Application Ref: H14-0065-26

Proposal: **Erection of 40 dwellings, garages and associated infrastructure.**

Location: **Land off Farnborough Close, Pinchbeck, Spalding, PE11 5AF**

Notice is hereby given that the County Council as Local Highway and Lead Local Flood Authority:

Scale (if A2): 1 : 250	Date: 05 / 06 / 2025
Drawing No: CHS 25-114-01	Rev:

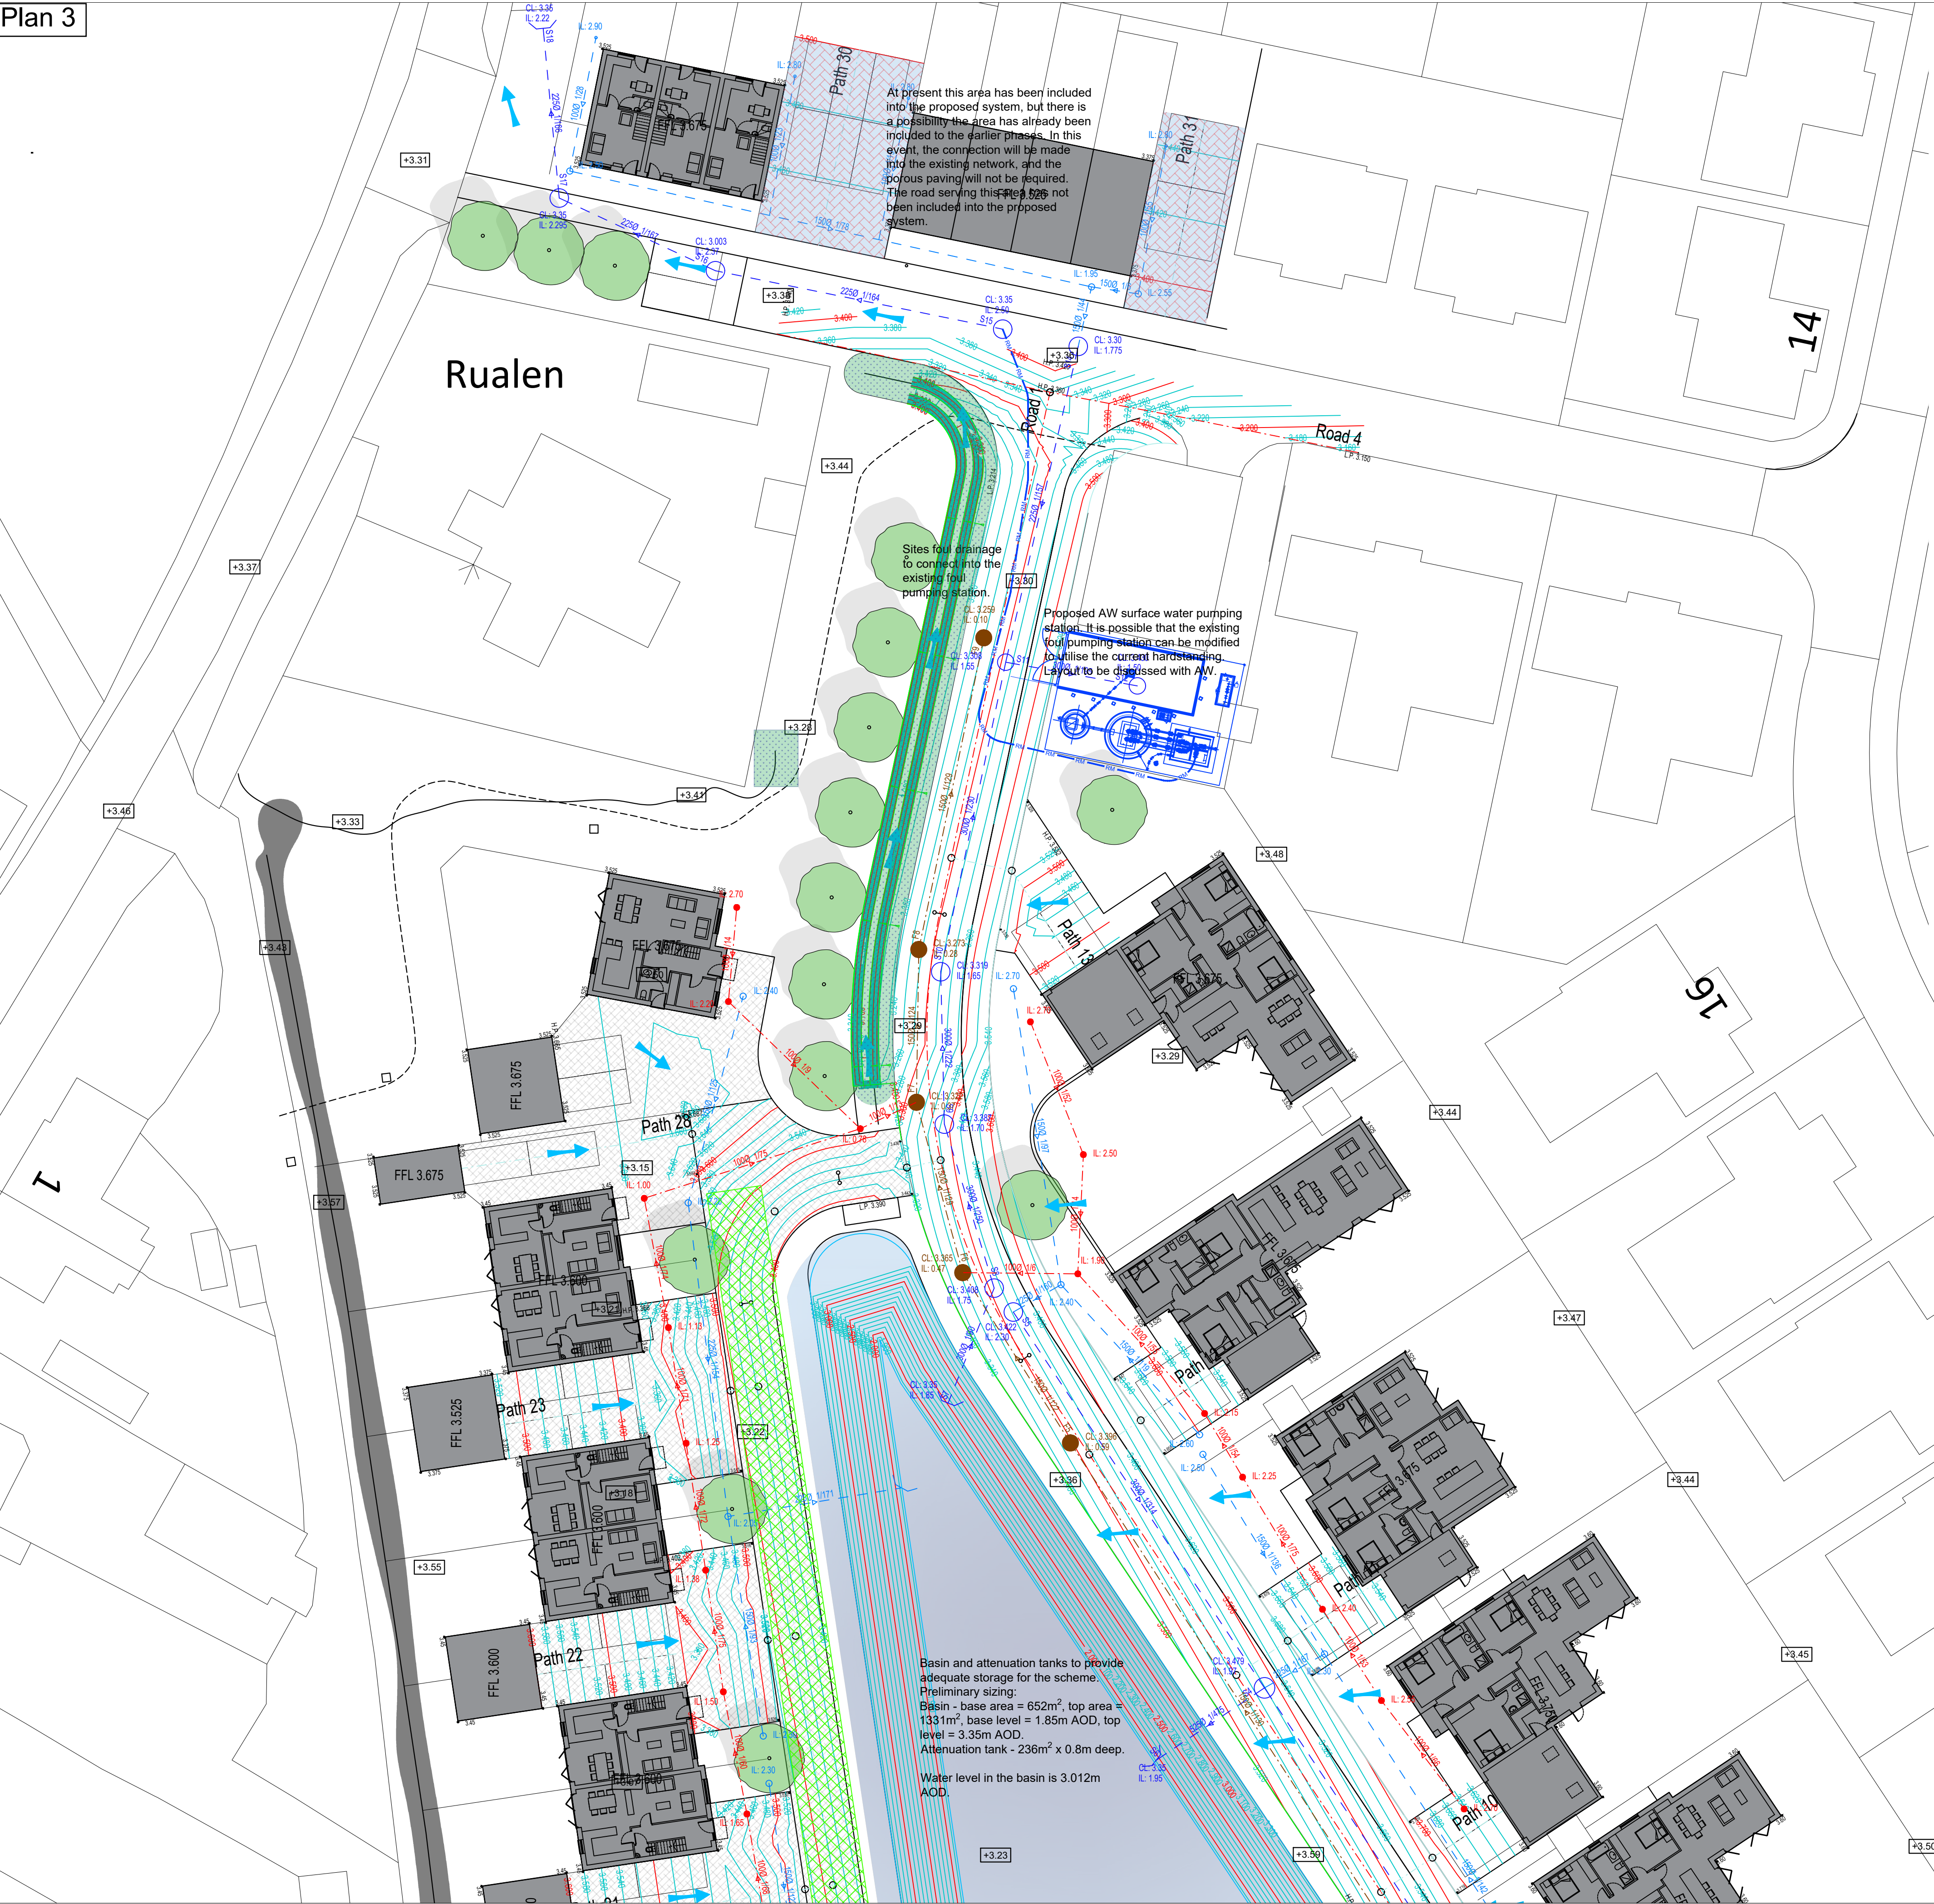
- The drawing does not show a flow control device.
- When was the groundwater monitoring done? It is stated that the water table ranges from 0.8m-1.8m. We request that 6months groundwater monitoring is provided at planning stage with a further 6months at Delivery stage. The test period should cover a Winter period. We have concerns that the SuDs will not work due to the presence of groundwater and that a conventional system may be more appropriate in this case. A conventional system can still include conveyance swales in certain locations.

- Will the basin be lined?
- Will the swale be lined?
- Headwall details are required – we encourage moving away from the precast concrete type as they are unsightly and there are more aesthetically pleasing ones that can be used.
